I am writing as a parent of a child that attends Darlington Public School regarding the proposed development by the University of Sydney, MP 07_0158 – Abercrombie Street Precinct, Syd Uni. Darlington Public School is an inner city school servicing the suburbs of Chippendale, Darlington and parts of Redfern. The school is directly adjacent to the western border of the project.

SITE PLAN

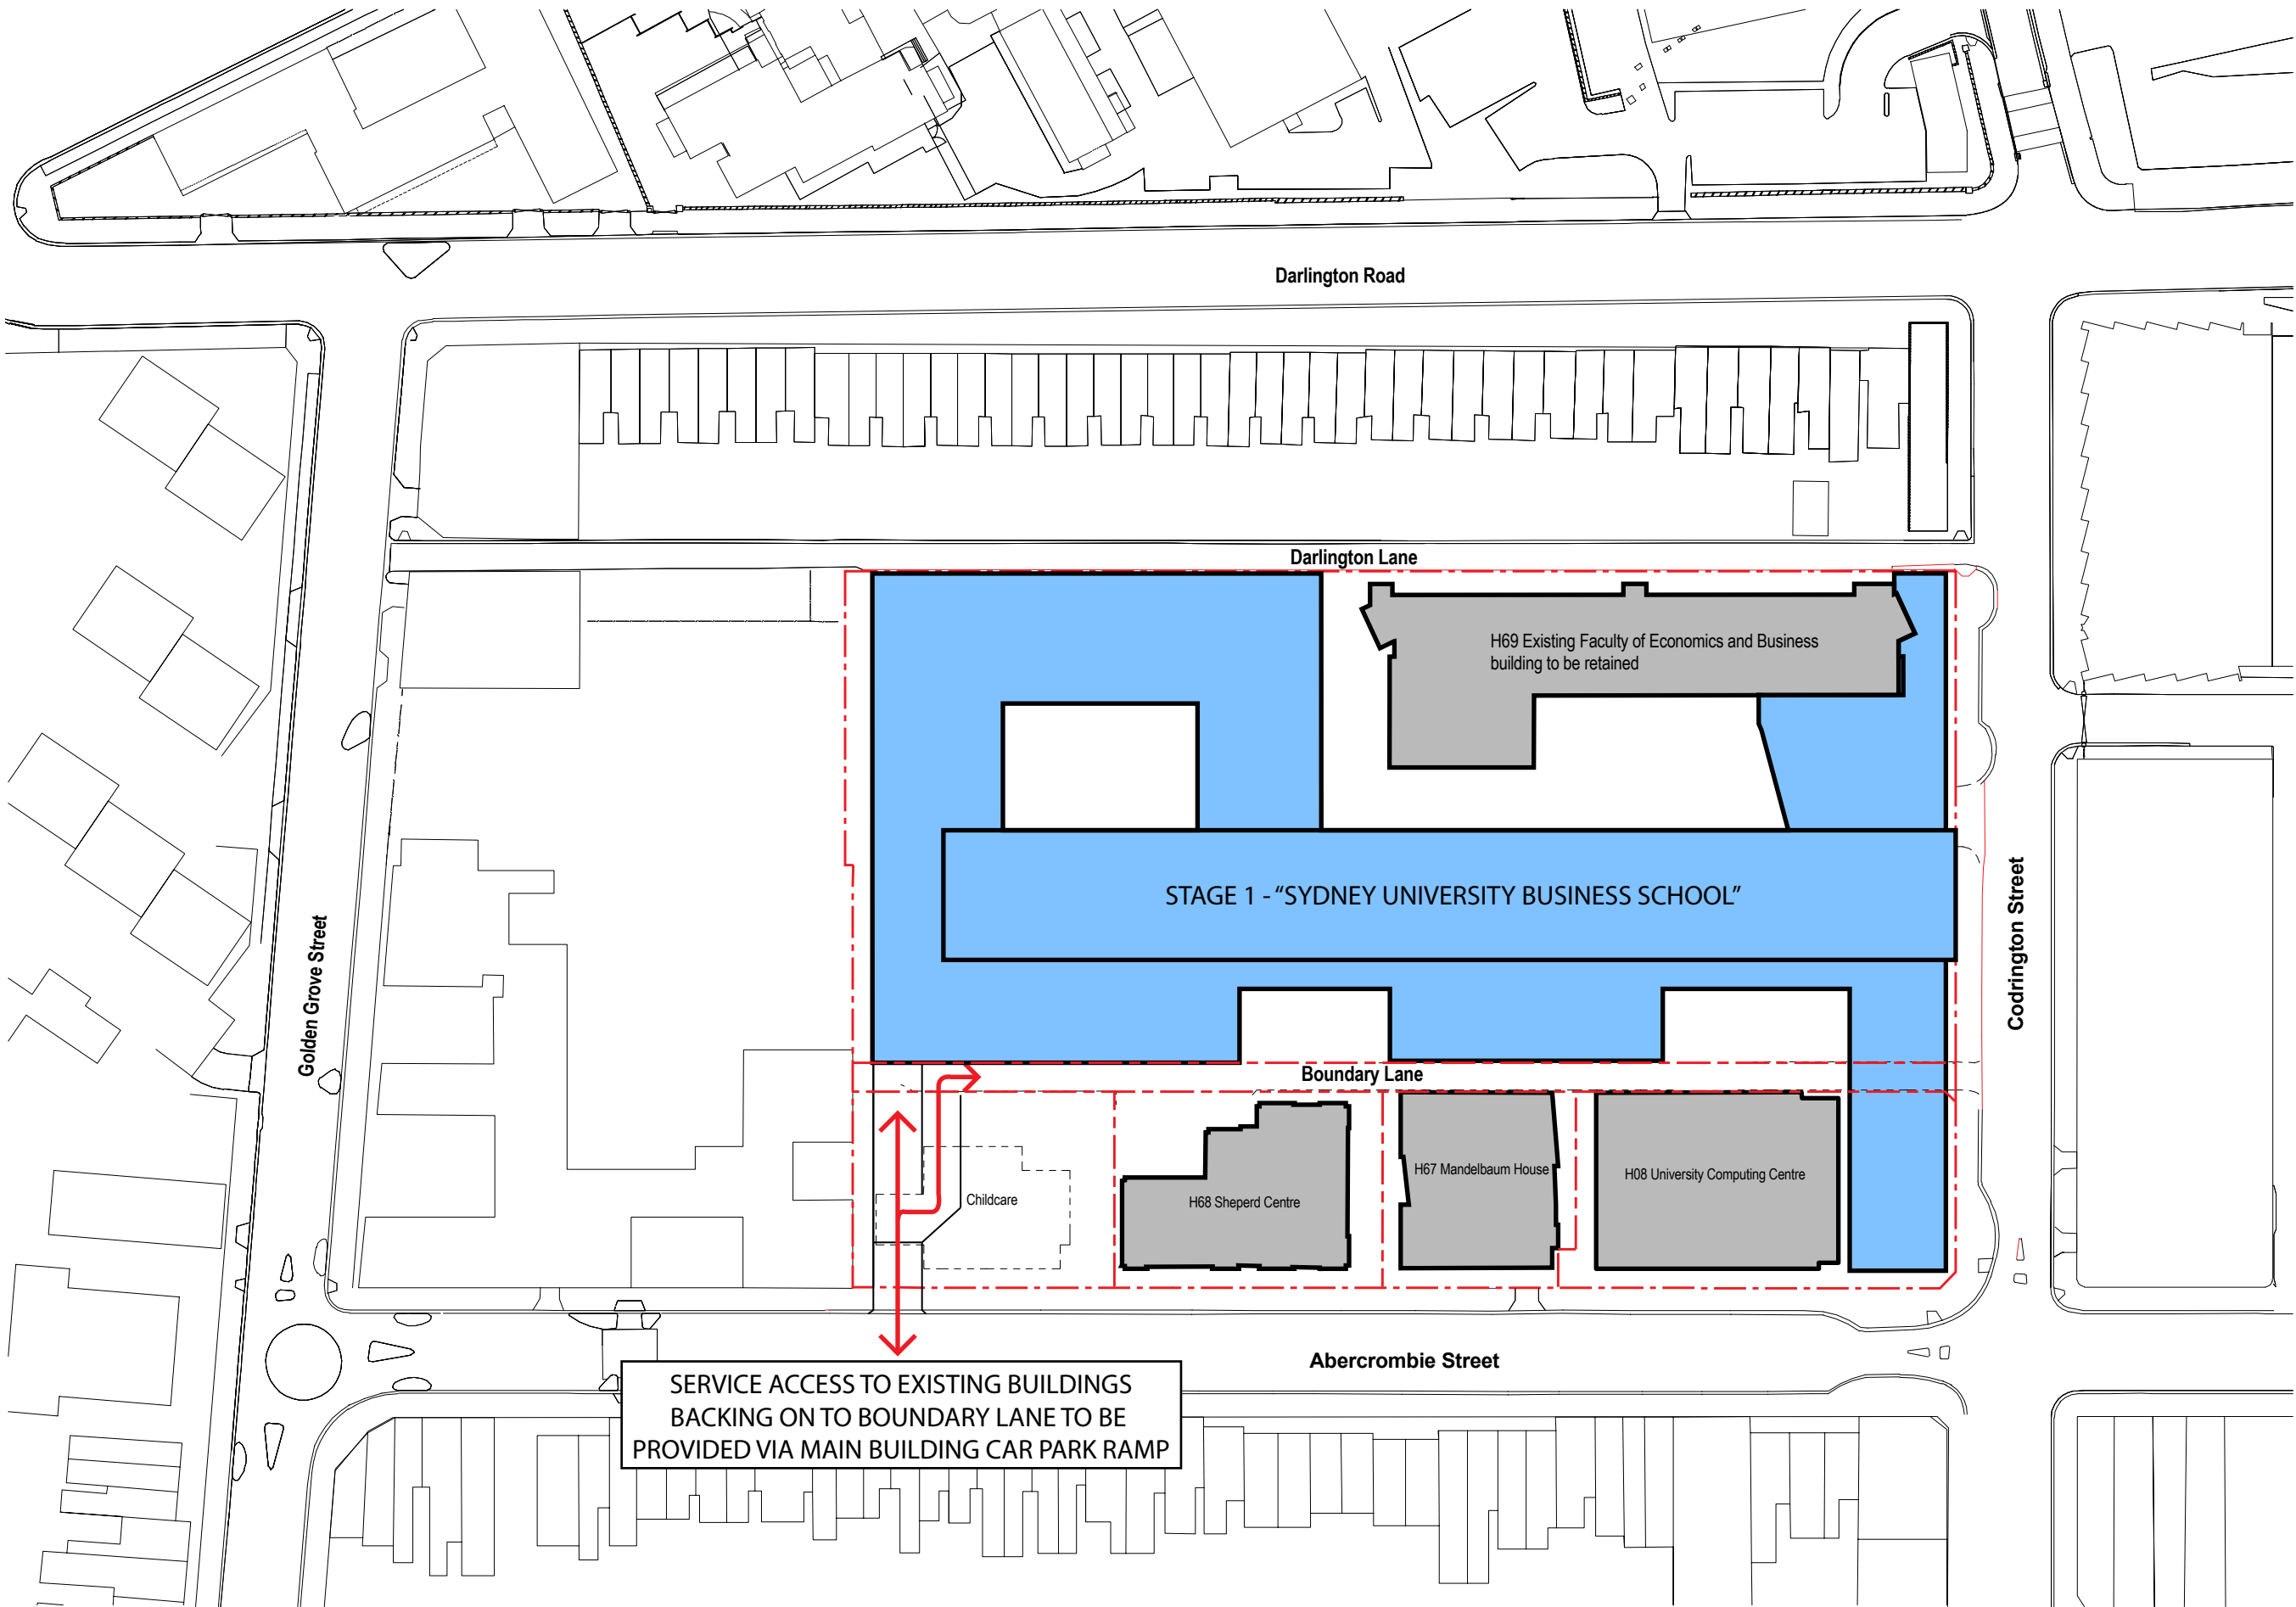
The proposed access point for the site is on Abercrombie Street and is directly adjacent to the school classrooms on their North East border of the school site. Locating the access point for trucks would:

- produce unacceptable levels of noise and vibration in the school classrooms that border that entrance – year 2, 4, 6 and both kindergarten classes. This is also particularly significant for the 2 kindergarten classrooms which face the development to the north with only glass panels and glass doors on that side.
- create an unsafe corridor for school children and parents that walk, or ride to school along Abercrombie Street (north side). This includes many unaccompanied but young children entering and leaving the school.
- create an unsafe car drop off and pick up point on Abercrombie Street (the main drop off point at the school).
- reduce the drop off and pick up point area for numerous children who are transported by car.

As per the current development plan, the proposal calls for an underground car park to be built for the student accommodation and University staff. The car park will accommodate 185 car spots, and its entrance will be on Abercrombie Street, at approximately the same point of the construction access.

The concerns raised above about the access point to the construction site are the same for this car park access point increasing the risk to school children's safety, in an area that has already been highlighted through the respective organisations (Council, Police, and RTA). The increased traffic flows and access point are an unacceptable risk to the children who attend the school. There is no justification for this level of risk to a school community, particularly as the University has another street frontage without school or residential issues (the University being the only stakeholder for Codrington Street) and an access street internal to project (Darlington Lane).

Drawing title
DARLINGTON PUBLIC
SCHOOL WORKS

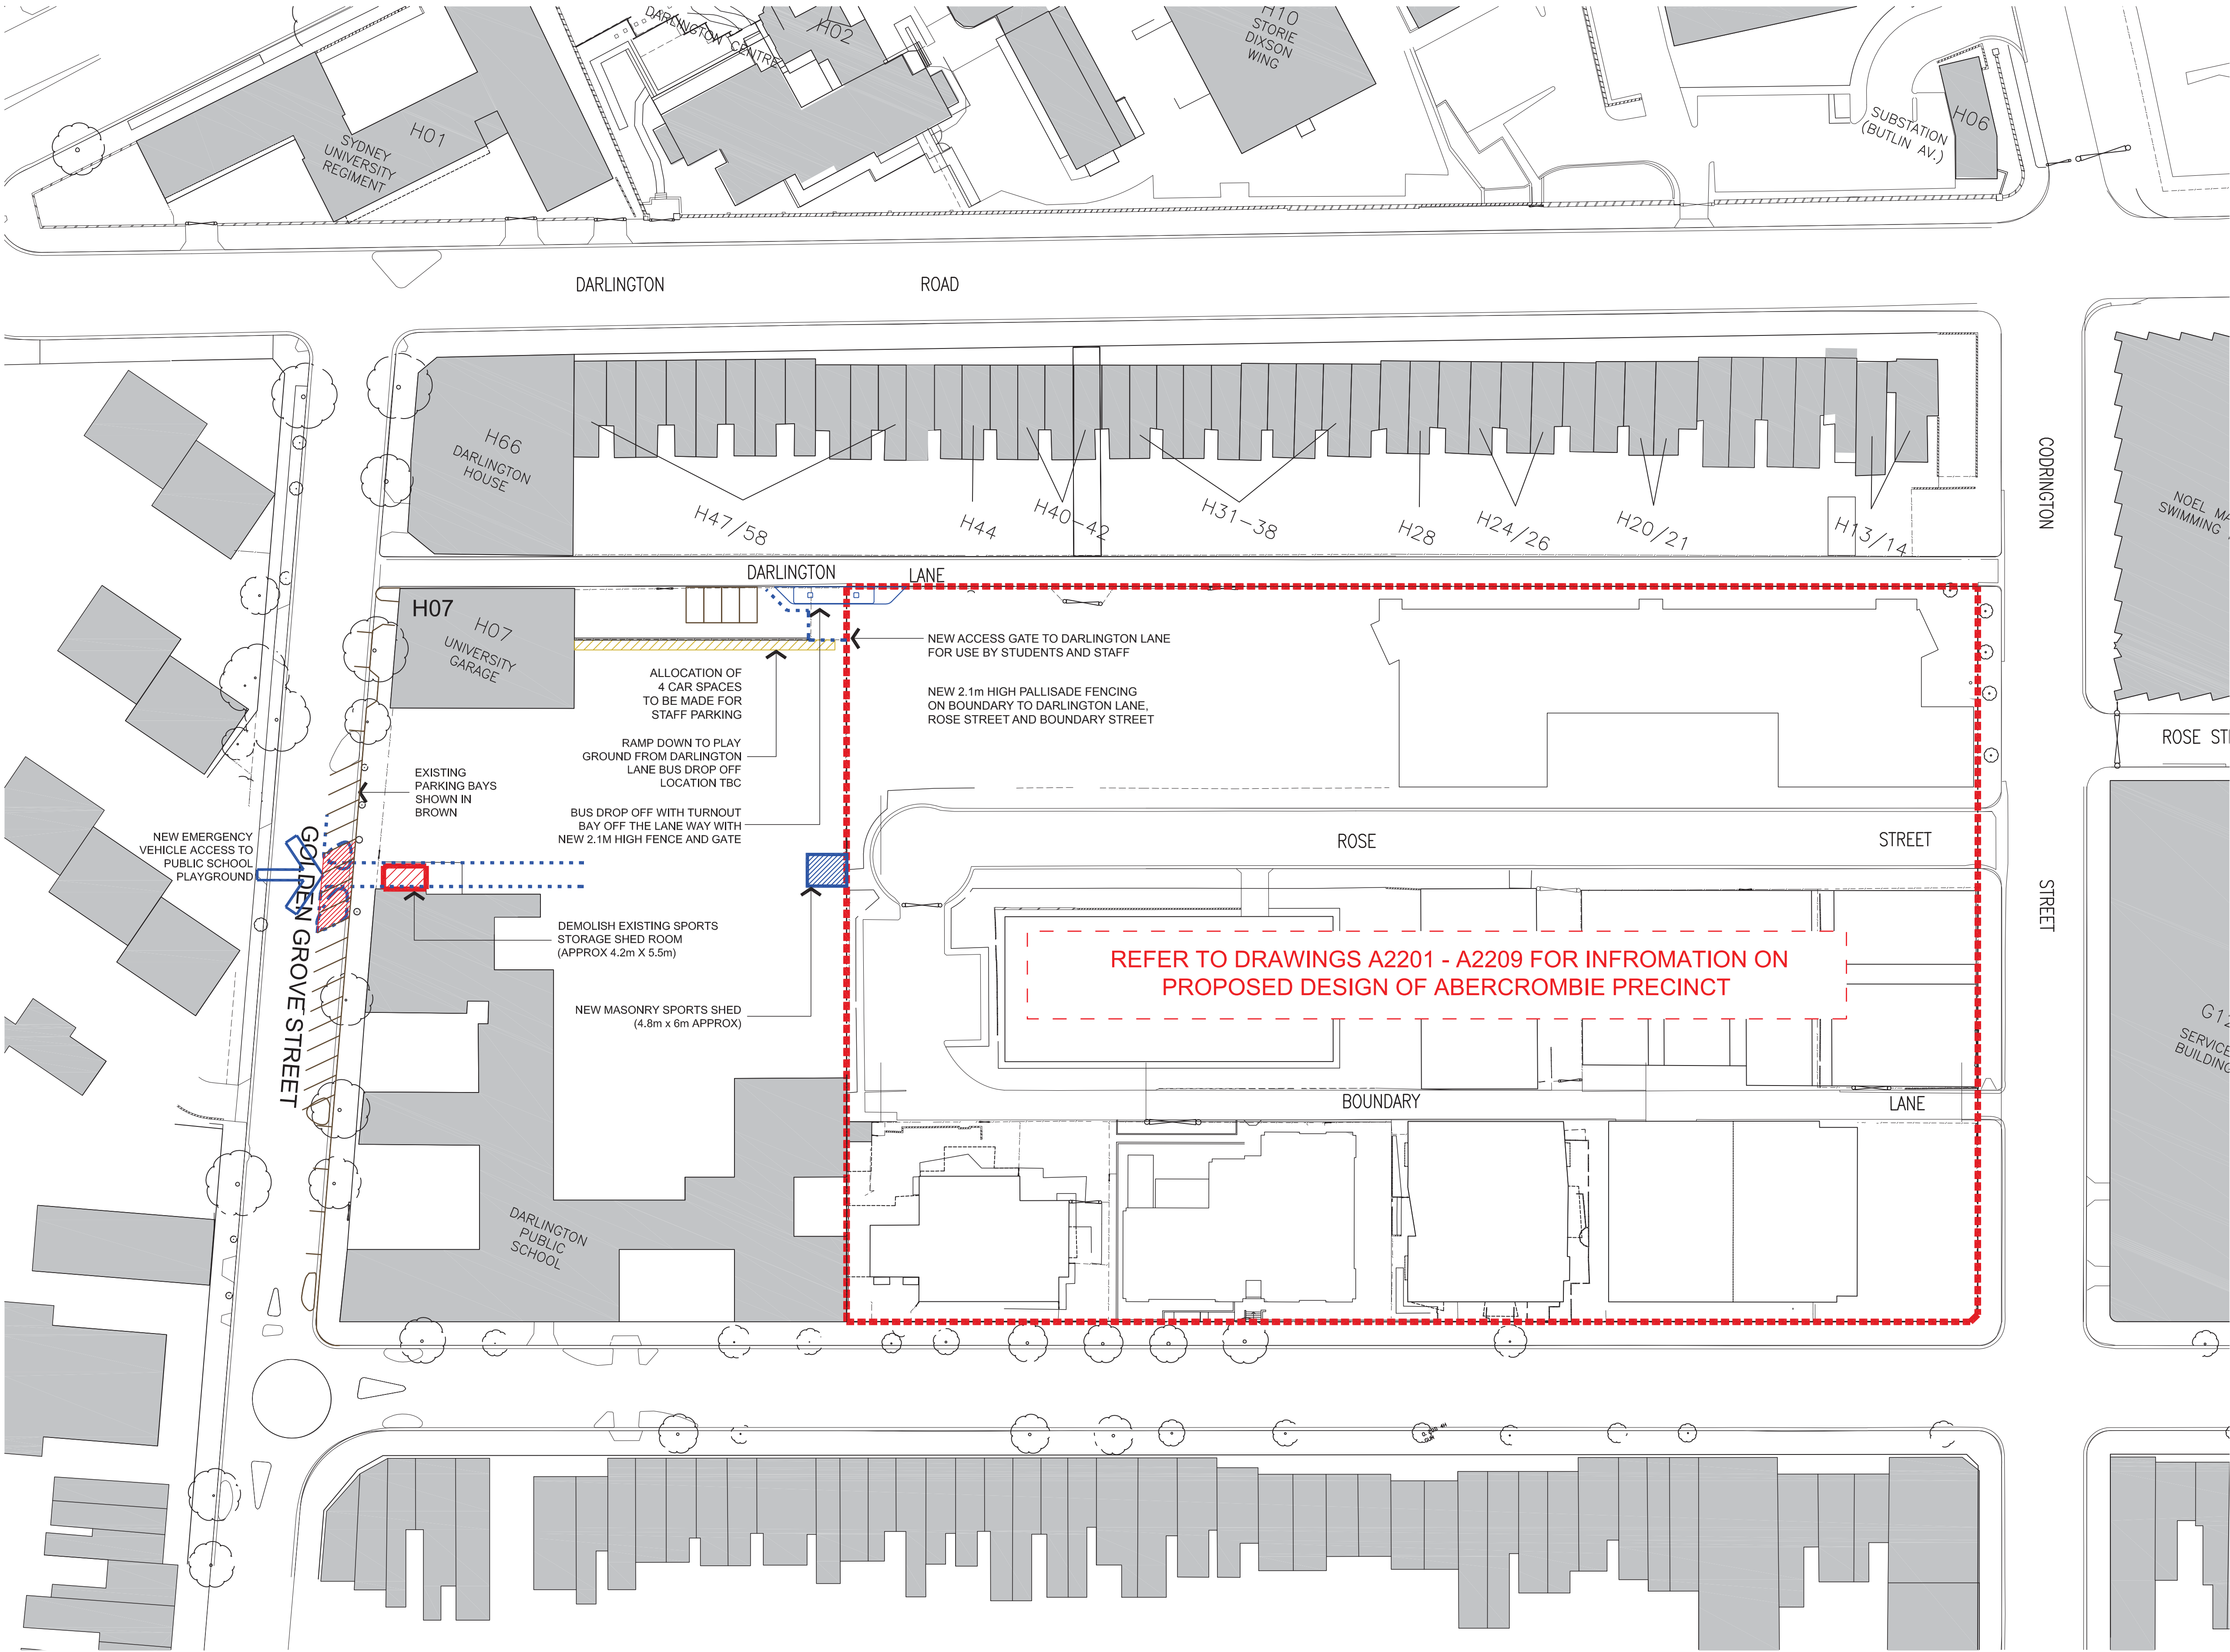
The project's Noise Impact Assessment concludes that noise associated with construction activities has been found to exceed the noise management level of the *Interim Construction Noise Guidelines* and that this assessment of noise impact has been based on a 2m high acoustic barrier being installed on the western boundary of the site adjacent the school.⁴

This level of noise impact is unacceptable for the learning environment of the school and as noted above, the school is even unable to shut windows to address noise levels.
